liquor license

| Lio Restaurant | 3 Spring St, Portland, ME 04101 | coming soon.

Jon Rioux and I reviewed the permit records this morning, I believe he has contacted you. See the list below of what is required to move forward with the issuance of the CO and Business License.

LIFE SAFETY - FIRST FLOOR PLAN

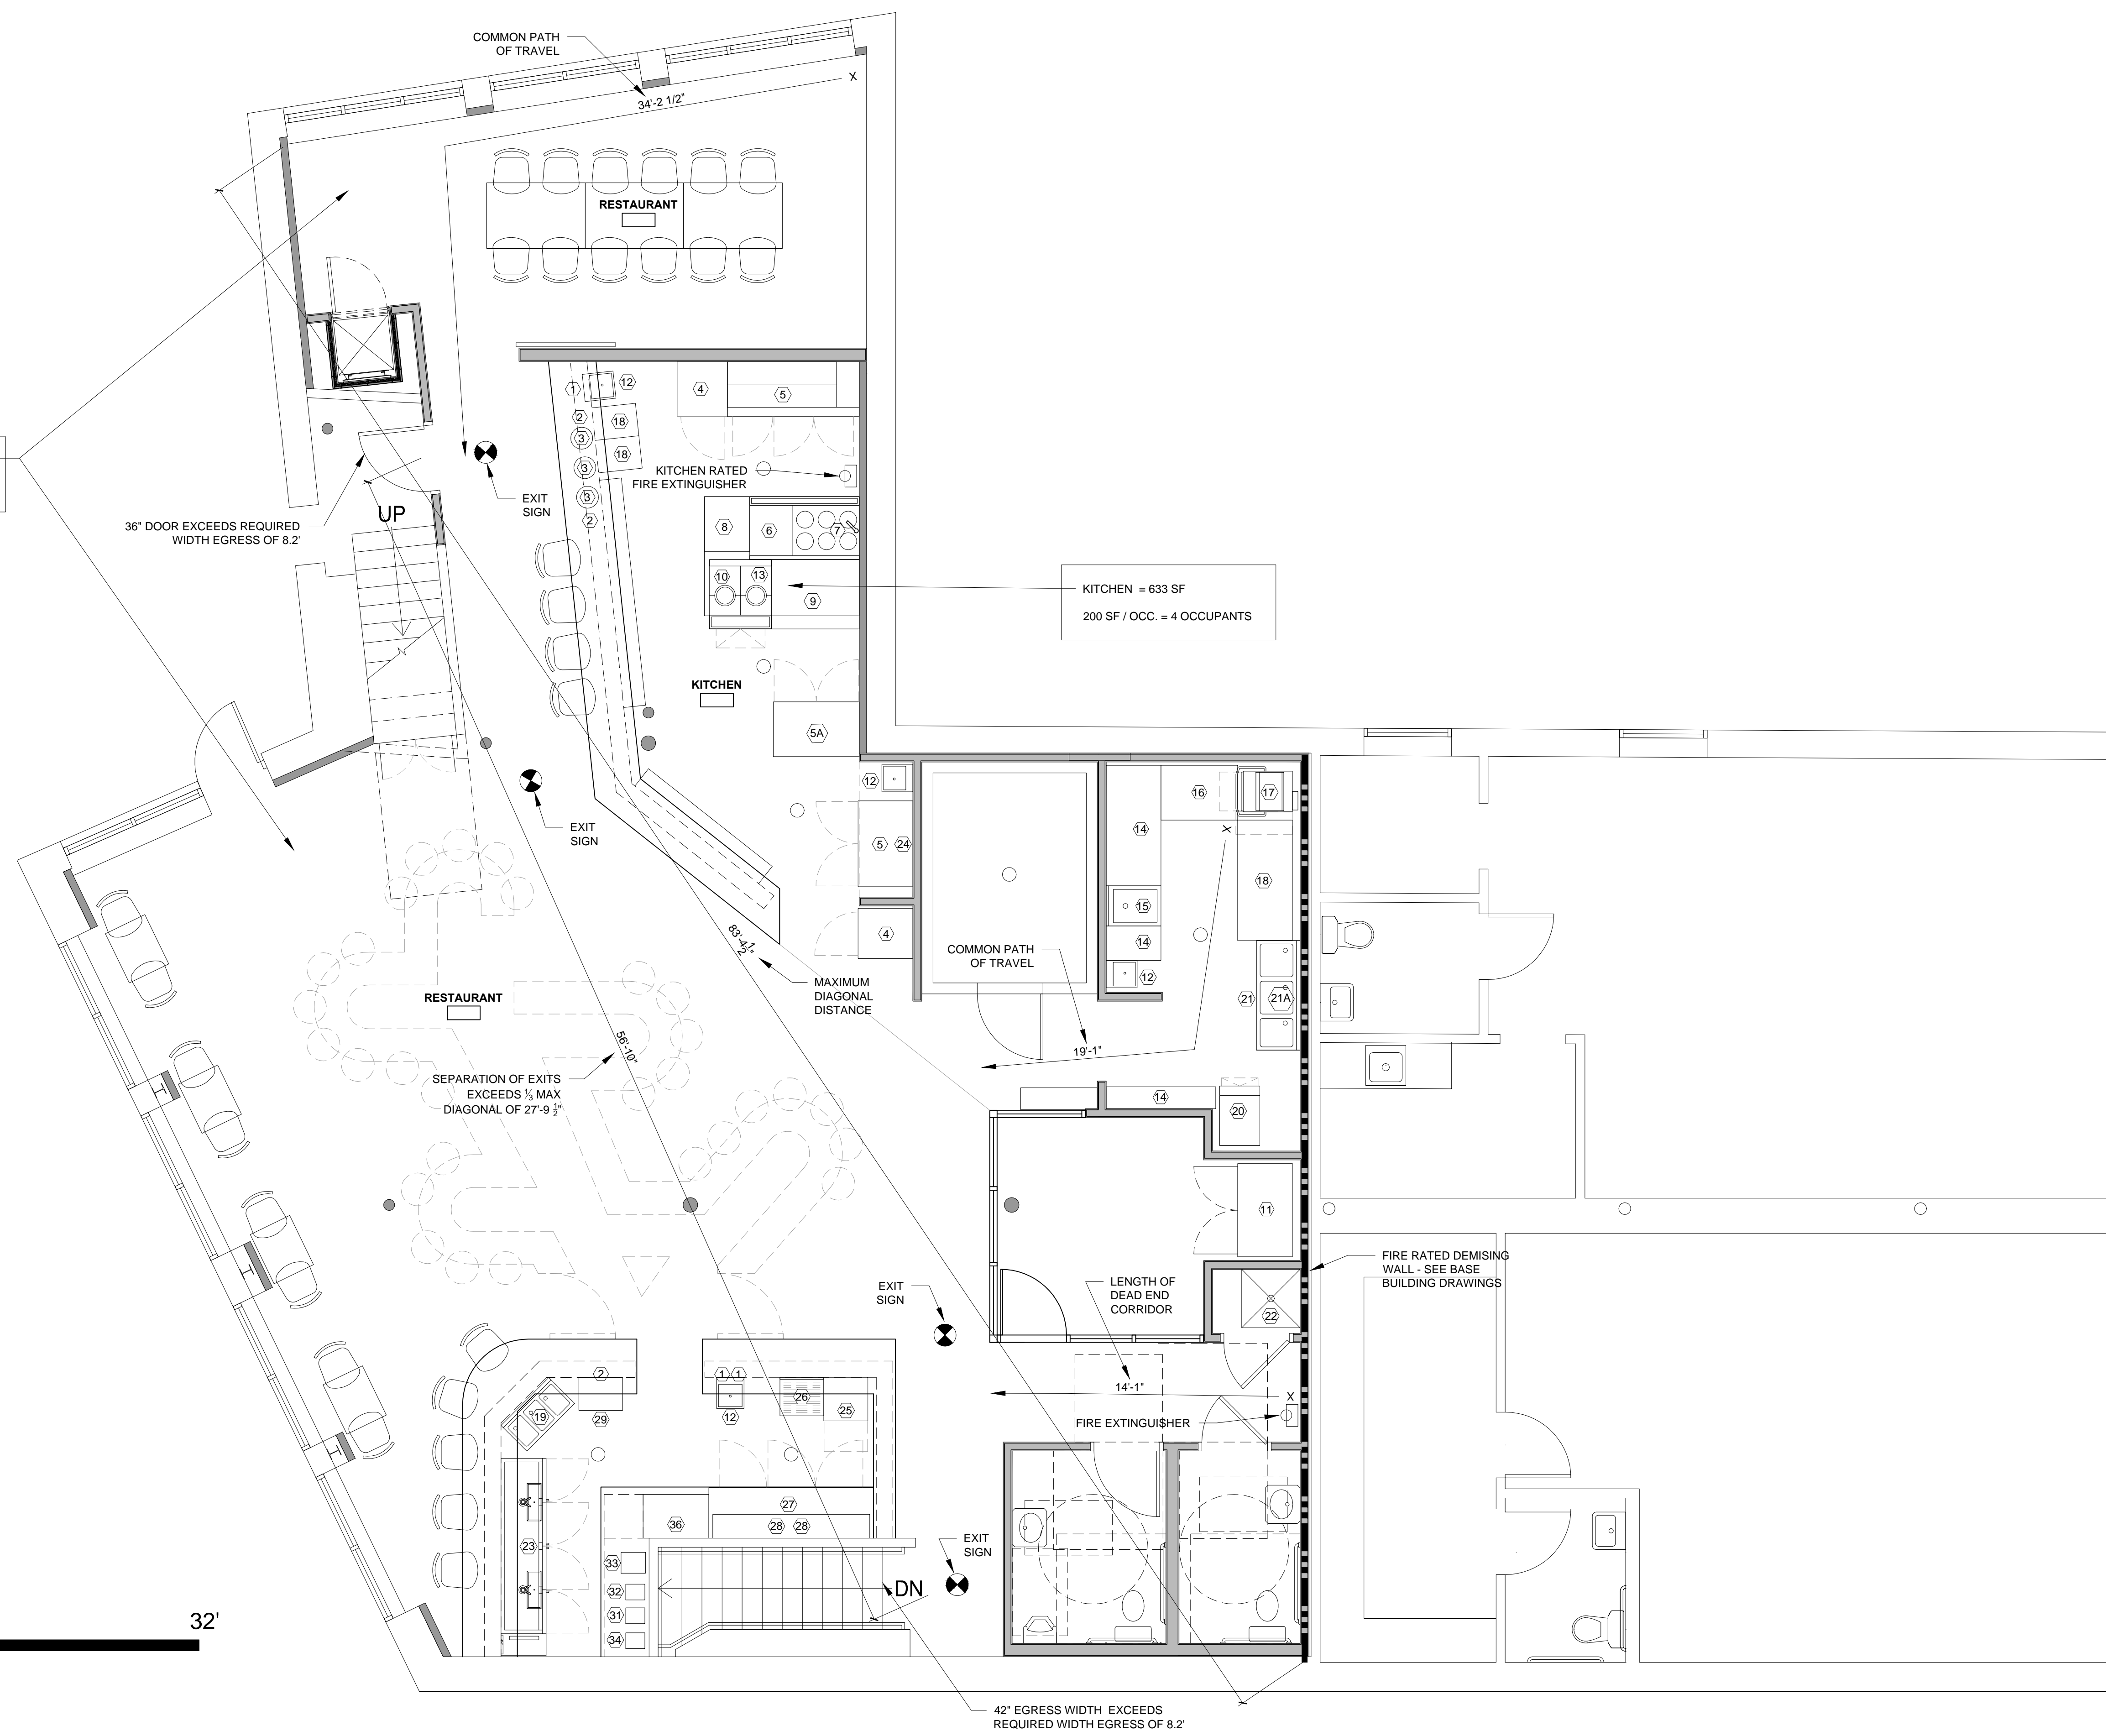
Nonetheless, this is different than how the occupant load is calculated for the building permit and the CO. The architect does this calculation based on square foot area for chairs and tables, standing areas and fixed seats. The outdoor areas were not part of the restaurant design calculation, and that needs to be accounted for now.

1. The seating plan no longer shows seating at the kitchen bar, is there a bar built to accommodate seating at any time?
2. The dumbwaiter is not shown on these plans, was it installed as per plans as a 1 hour rated shaft and door assembly?
3. The deck is part of the approved tenant space and is therefore required to have an occupant load for the CO. The square foot area needs to be calculated for either tables and chairs (15sf/pp) or standing room (7sf/pp). This needs to be consistent with the amount on the business license. Access to the basement bathroom is required, how will this be achieved? The health inspectors will need to approve any travel through prep areas.

2. The dumbwaiter is installed per plan, the shaft is 1 hour fire rated, I don't know about the door, but will have someone look at it and make sure it is also 1 hr rated.
3. Ryan Senatore tells me "the deck is 243 sf (excluding egress pathways to the doors) so 243/15 for tables and chairs it is 16 occupants on the deck
4. We can provide access to the basement bathroom most easily through the kitchen prep area – there is a clear pathway around the kitchen prep area so patrons will not have to enter any of the prep areas, and we could delineate this further if necessary.

1. The 4 seats at the kitchen bar will be added back into the seating for a total indoor of 67.
2. I understand the dumbwaiter door will be changed and rated.
3. The occupant load of the deck will be added to the CO.
4. We can have one of the health inspectors check next week on the bathroom access and to see if anything needs to be changed.
